Sheringham Shoal and Dudgeon Offshore Wind Farm Extension Projects

Marine Processes Technical Note (Revision B) (Tracked)

Deadline 3

Document Reference: 13.5.1

Figure 6.11 Zone of Potential Influence on the Tidal Regime

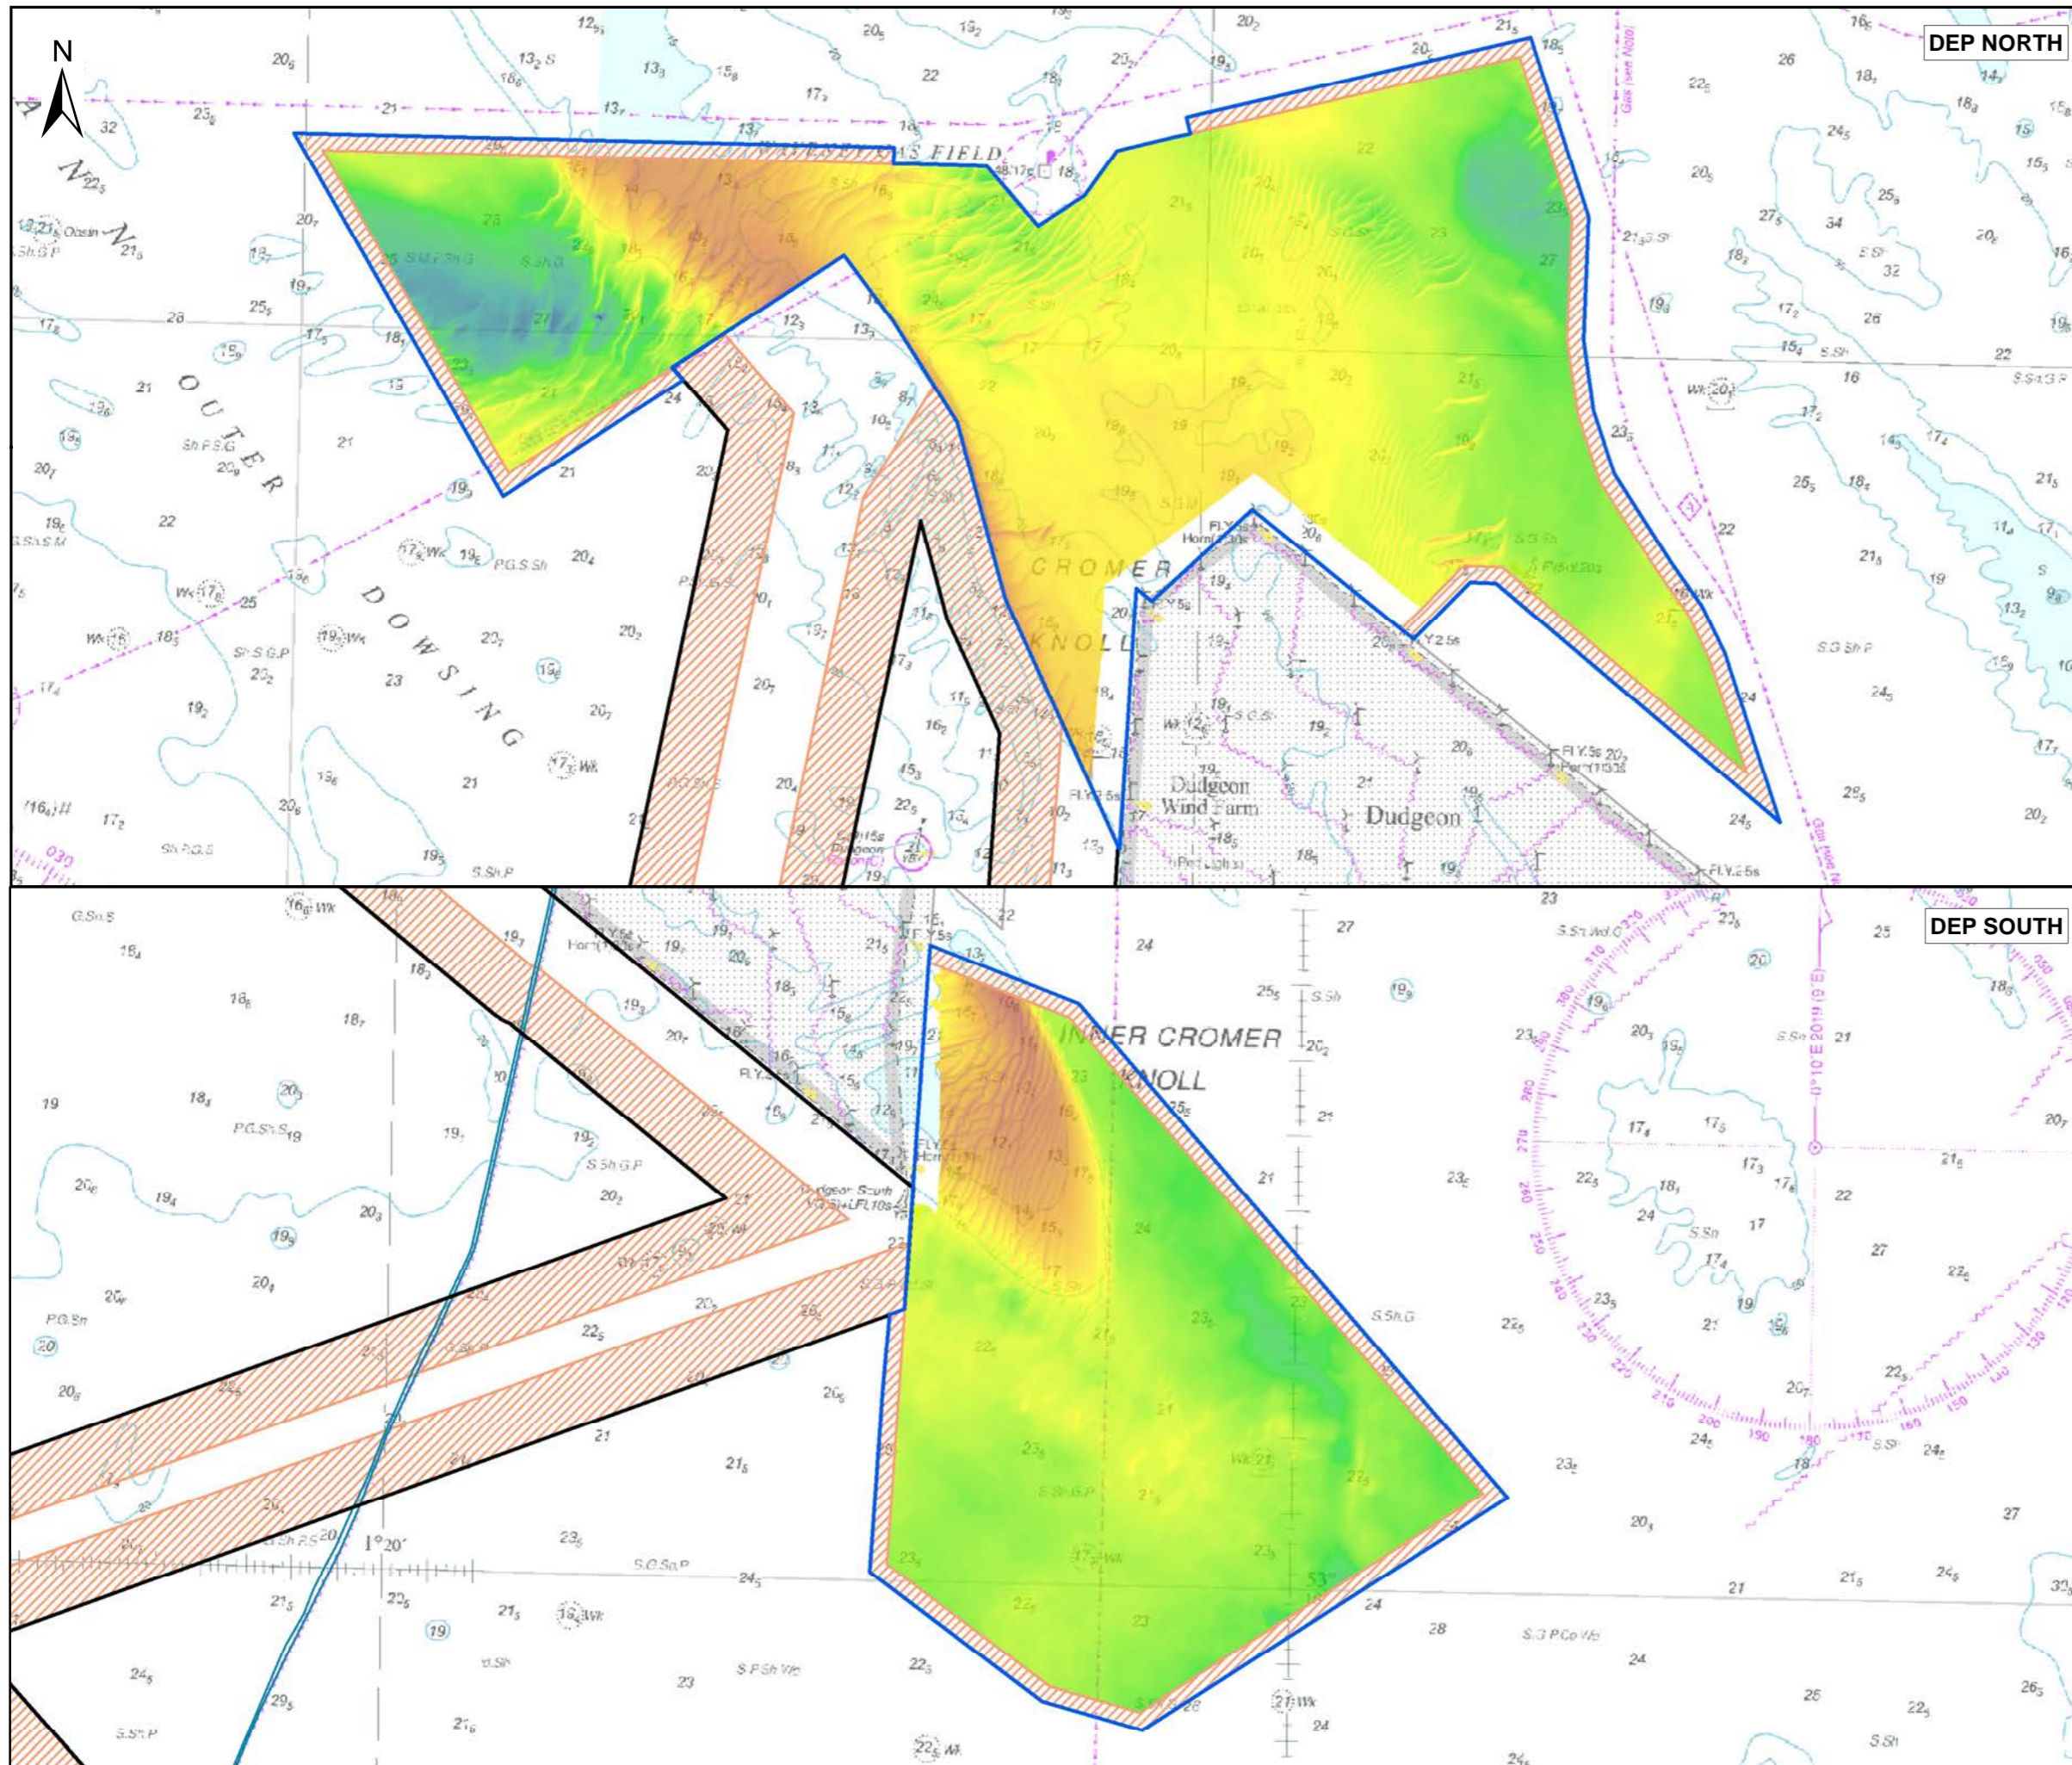
23-24. ID 47: *Point 316. The maximum zone of potential influence (ZoPI) on the tidal regime is presented in Figure 6.11, which we welcome. However, marine protected areas have not been identified on this map. It would be useful to identify marine protected areas on Figure 6.11 to show where they overlap with the ZoPI.*

24-25. The updated Figure 6.11 is provided as **Figure 10**~~Figure 10~~ below. With respect to the overlap shown with the Inner Dowsing, Race Bank and North Ridge Special Area of Conservation (SAC), the potential increased suspended sediment concentrations (SSC) and deposition effects during construction, operation and decommissioning; and changes to physical processes resulting in changes to sediment supply (i.e. sediment transport effects) during operation (but in relation to the SEP wind farm site only), are assessed within the **Report to Inform appropriate Assessment (RIAA)** [APP-059].
